Online Comment

Application H16-0233-26
Location Land off West Marsh Road Spalding PE11 2BB
Proposal Proposed LNG Refuelling Station

Name National Grid Electricity Distribution
Address formerly Western Power Distribution

B	NOTES REVISED	27/03/2026
A	REVISED TO SUIT EQUIPMENT BEING INSTALLED	16/03/2026
Rev.	Description	Date
Title:	LNG REFUELLING STATION - SPALDING WEST MARSH ROAD, SPALDING. PE11 2BB PLANNING	 Sheet: 1 OF 1

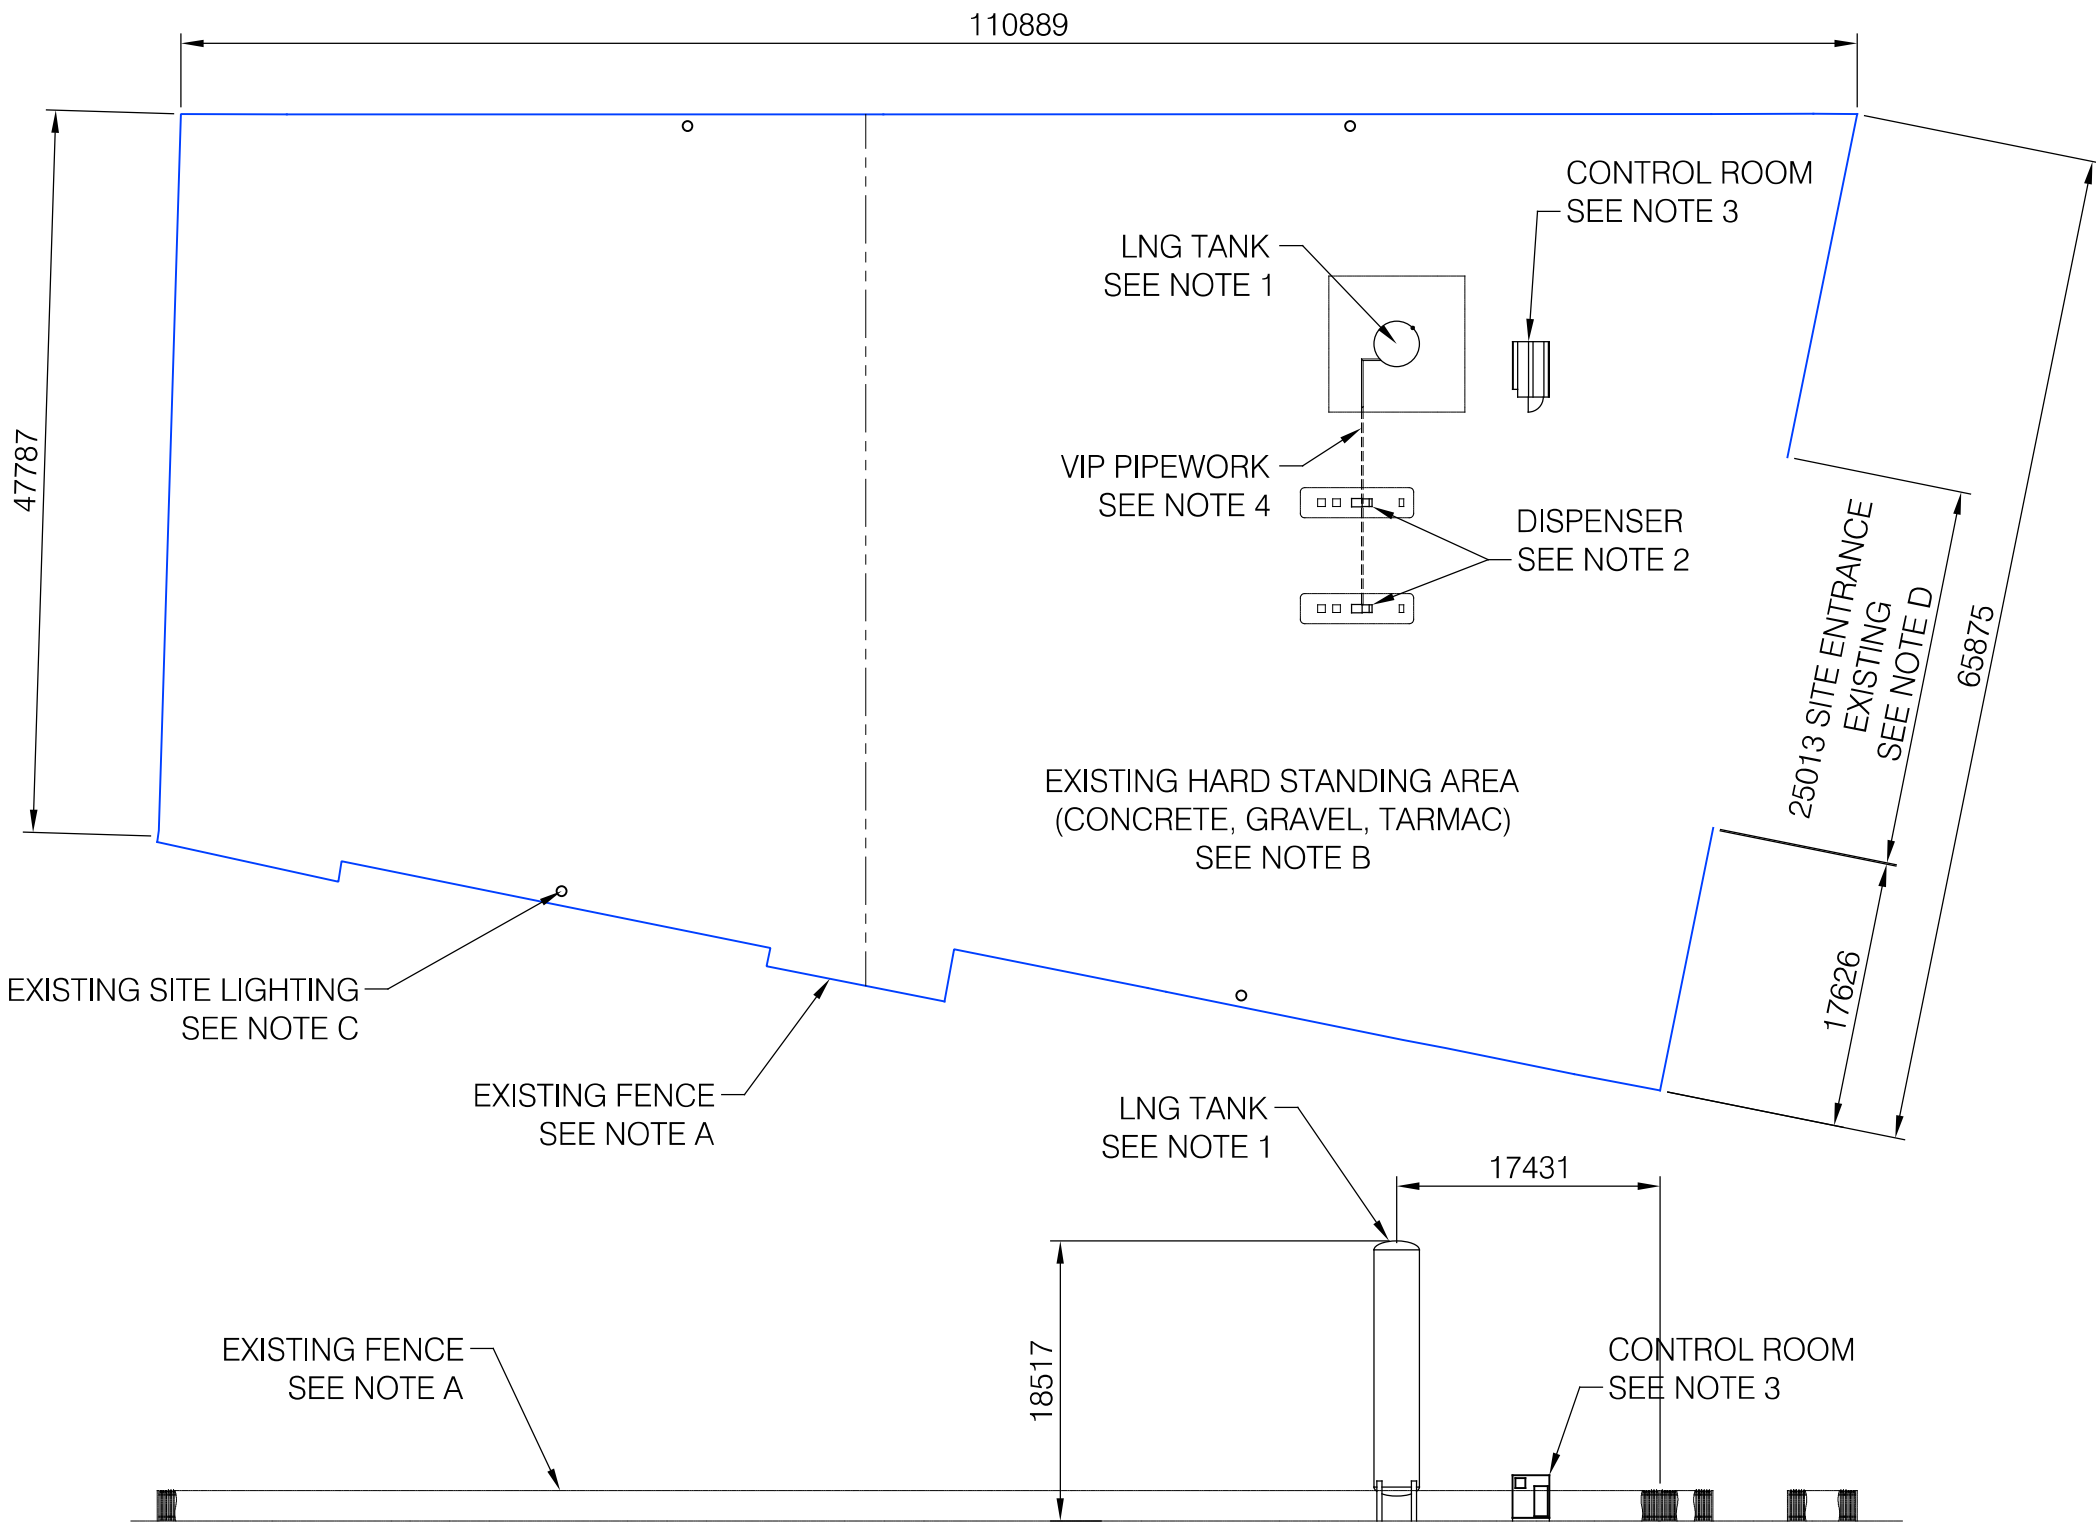
Please note there is an 11kv UG cable running across the site entrance. Please contact NGED if you need assistance.
